RE: Jersey Mike's -
The Square At Lillington
NC HWY 210 S
Lillington, NC 27546

Fire Marshal Review Comments:

SECTION VIEW - MODEL 542ND-2-PSP-F HOOD - #1

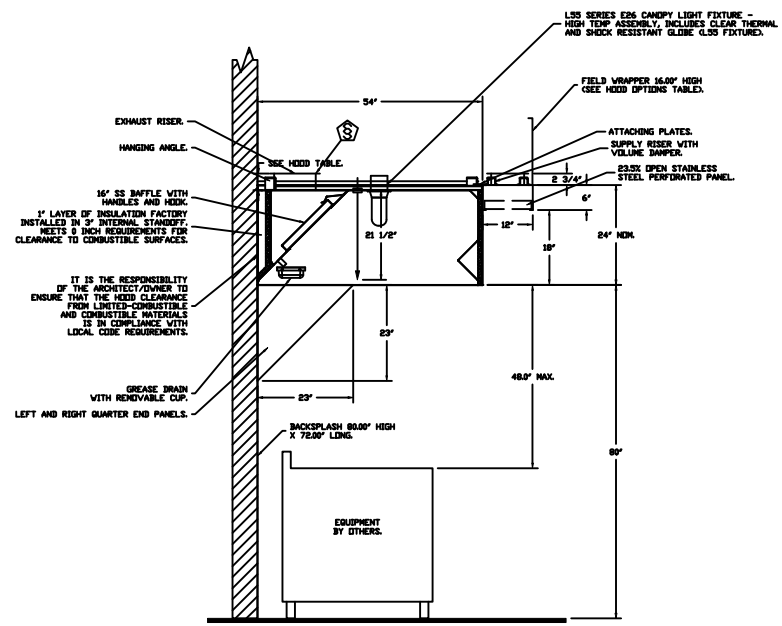
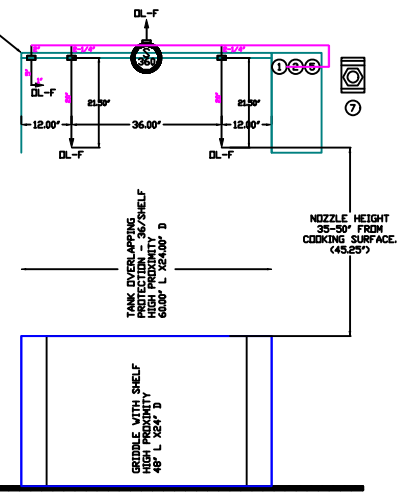
2) Needs to submit Hood plans and the appliances that will be used under the hood.

RESPONSE: Hood plans are included in the Mechanical sheets are from Captivaire for the project. The Bread Oven at he back of house (#10a) and griddle in the production area (#22) are the appliances under the hood.
